Our Ref: 1160-8-25

Your Ref: Stage 3 (SSD 57703458)

**Re: Regents Park In-fill Affordable Housing – Stage 3 (SSD 57703458)
Response to submissions – Traffic.**

FIGURE 3-B85 NORTHBOUND
EXIT B99 ENTRY SOUTHBOUND
TO BUILDING C DRIVEWAY

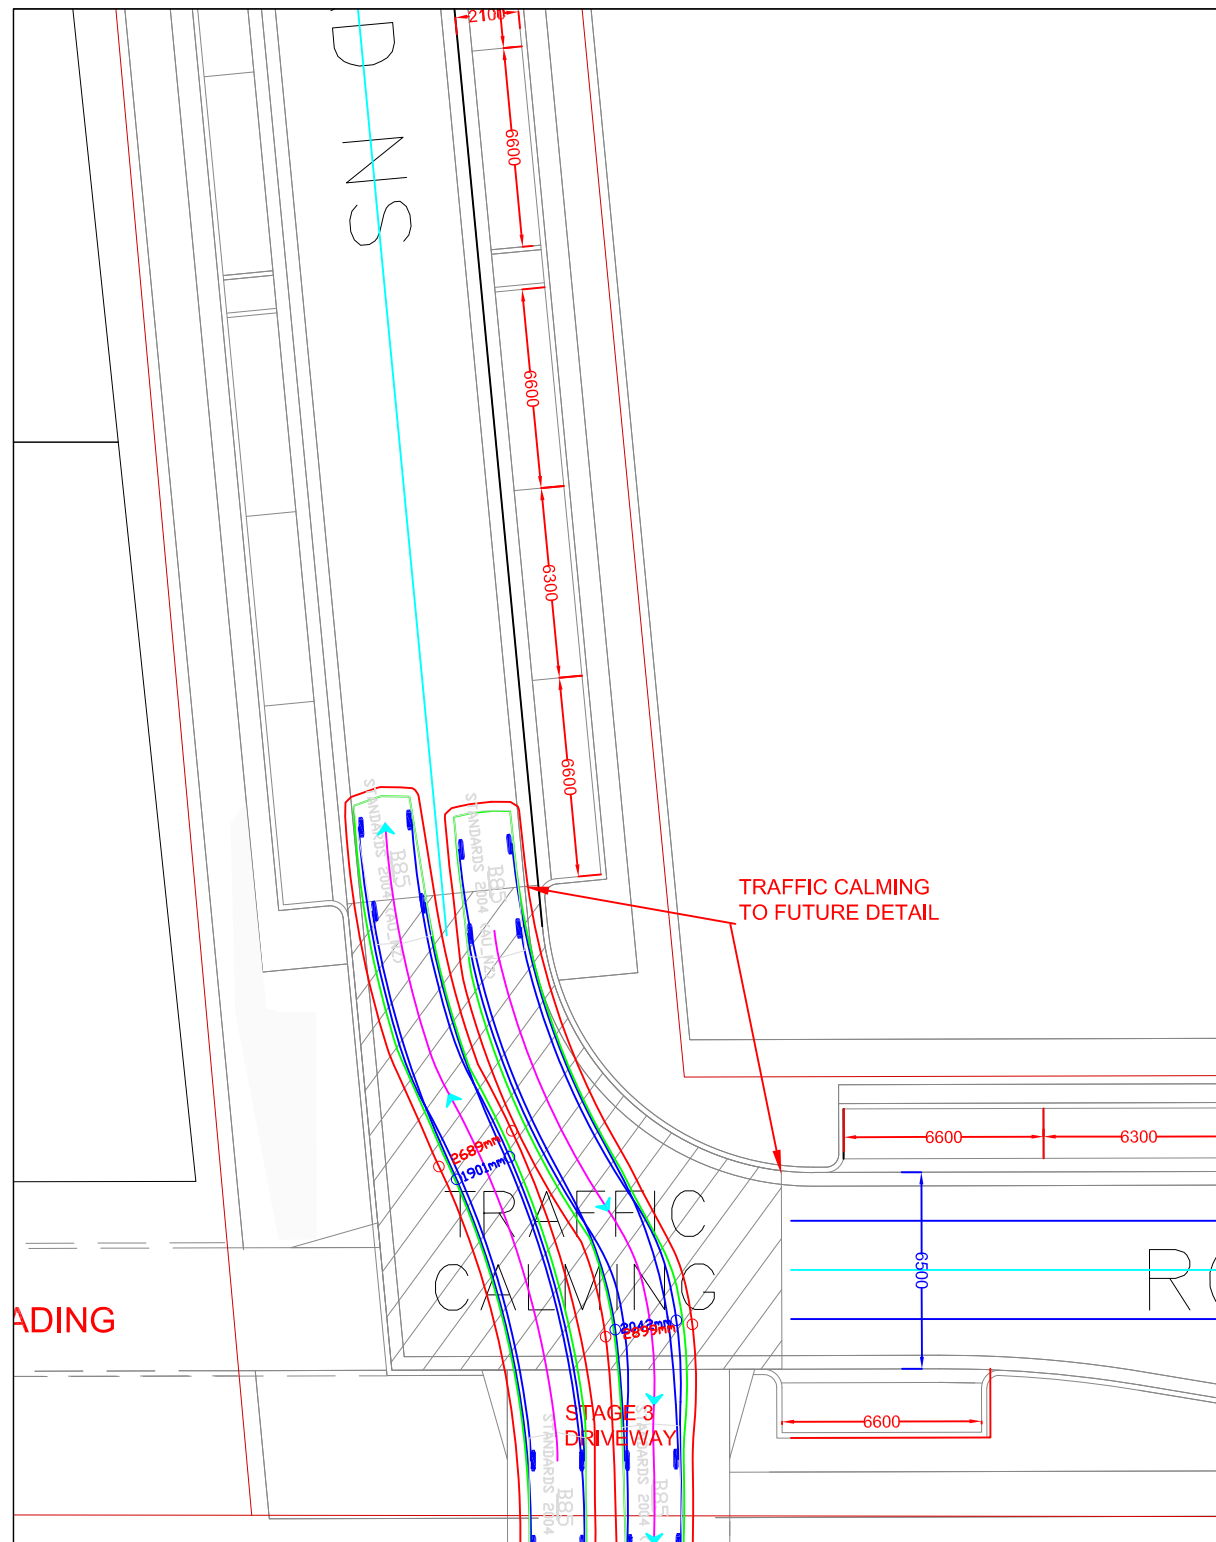
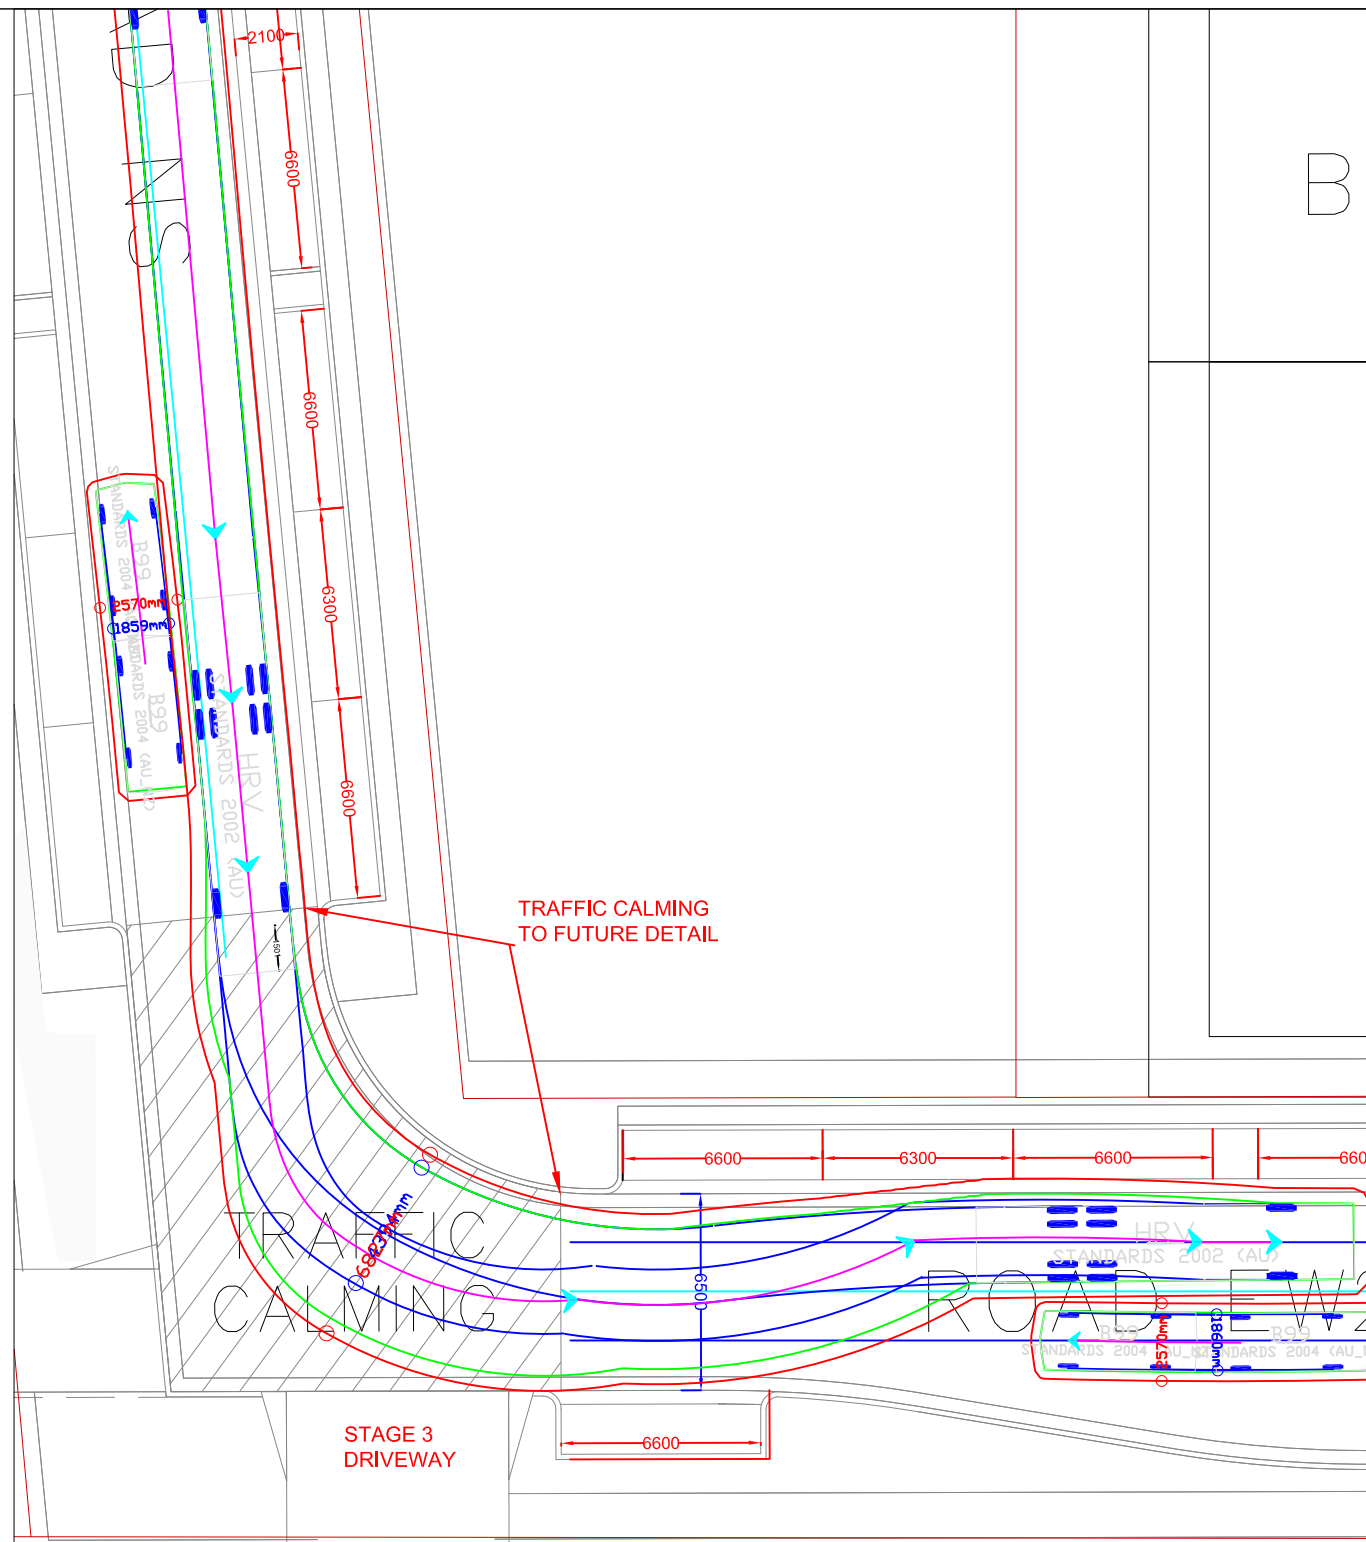
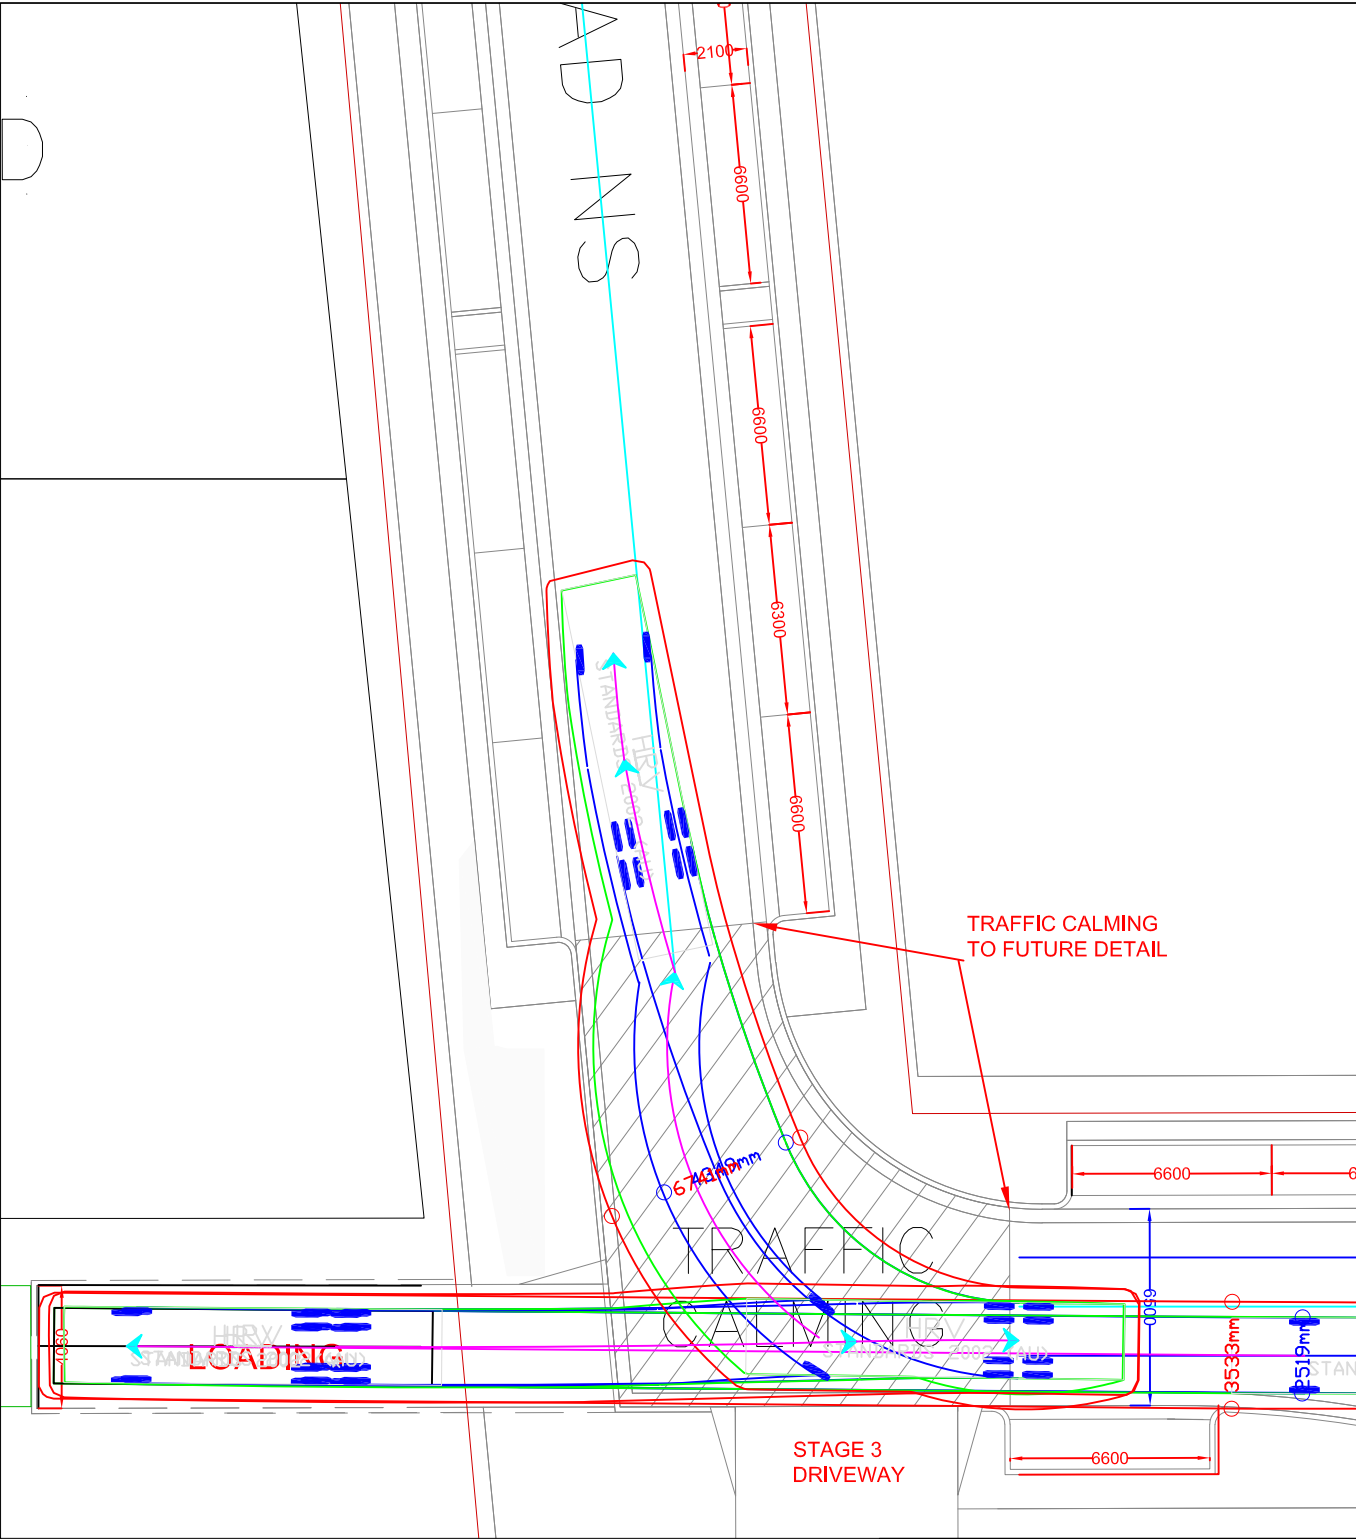
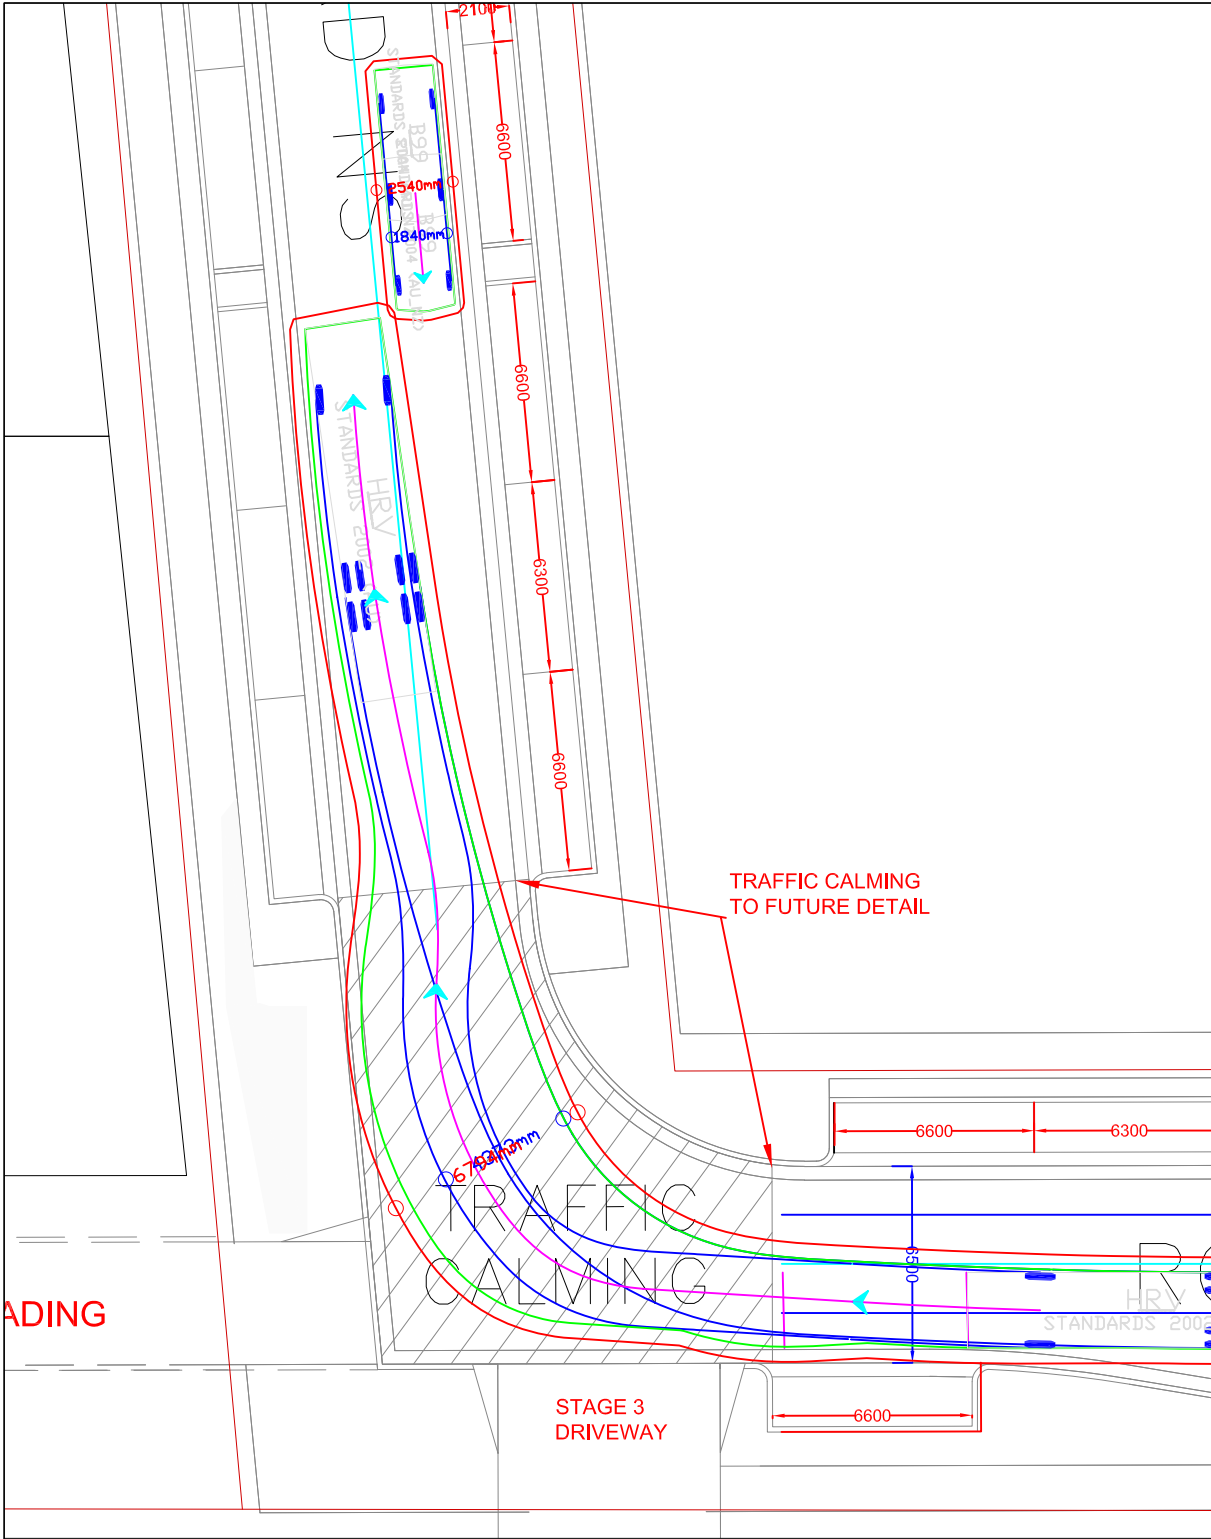
It is acceptable that the driveway width need not strictly comply with AS 2890.2. However, the Applicant must provide more legible and accurate turning path diagrams.

The submitted swept paths currently show significant overlap. The Applicant must demonstrate simultaneous entry and exit movements for a 12.5m HRV together with either a B85 or B99 vehicle for each driveway.

In addition, when a vehicle is waiting to turn right into the proposed site, the Applicant must clearly demonstrate that there is sufficient safe clearance for southbound vehicles to continue through without obstruction. The two internal roads must be wide enough to cater for footpath and services and in line with Council's standard. To be referred to Infrastructure Service.

It is noted that the on-street parking along the frontage of the site is being used for vehicles entering and exiting the property — effectively serving as merging and deceleration lanes.

Moreover, the deceleration area is shown within the existing Bus Zone, which is not acceptable. All turning paths must be designed and assessed so as not to intrude the Bus Zone (assuming a bus is stopped within the Bus Zone).

Turning paths needs to be reassessed and may require considering a wider driveway to improve safety at this location and predominantly avoid congestion and delays on Auburn Road.

Updated swept paths have been provided with the updated TIA included with the response to submissions.

The public domain design and articulation will form part of the scope of the Voluntary Planning Agreement (VPA) currently under discussion with Council. It is expected that the final road layout will be resolved consistent Council's expectations as part of this process.
